From: Nicola Moore
Sent: 21 July 2020 15:29
To: [REDACTED]
Subject: FW: UKPlanningMaps.com order 482367 URGENT

Ref: FP/109/20/HH

The summer house measures 12ft x 7ft and this is to scale on the map.

## 19 The Midway, Bognor Regis, PO22 7HA

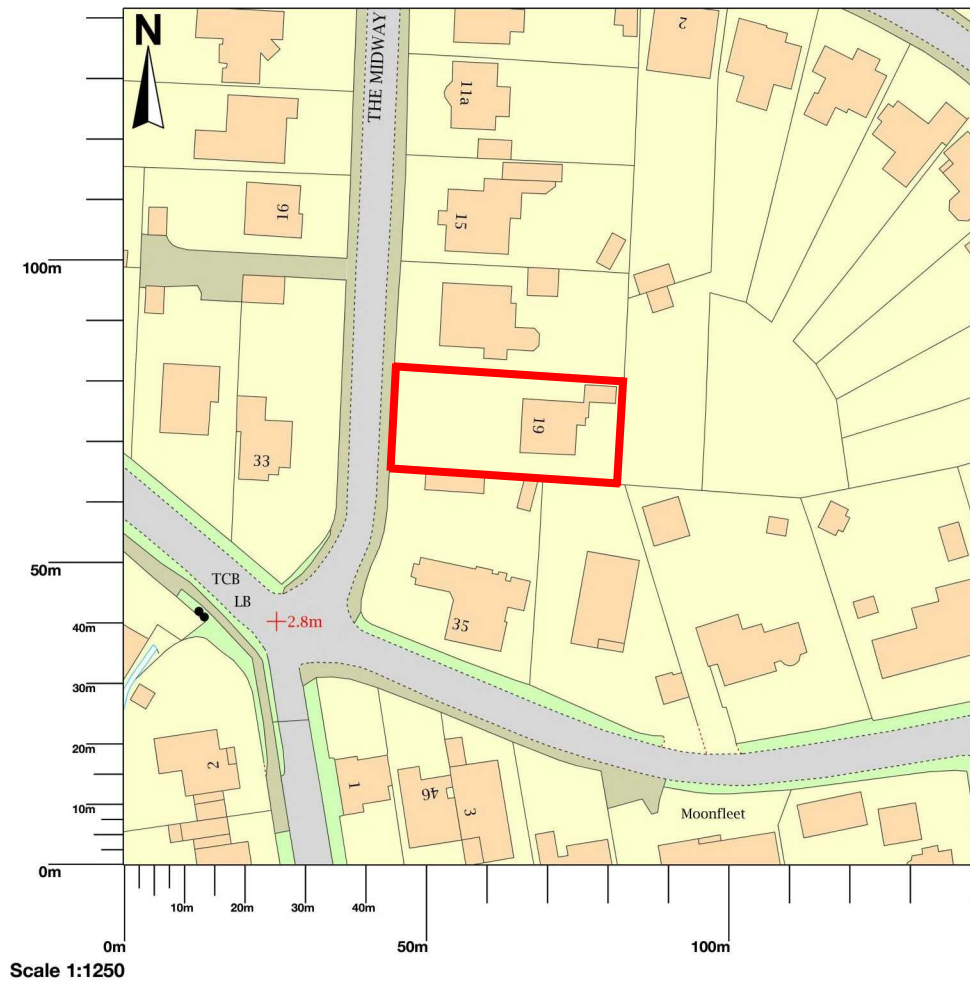
Thank you for your email, the plans are fine however location and block plan both need red outlines but with your permission I can add these for you.
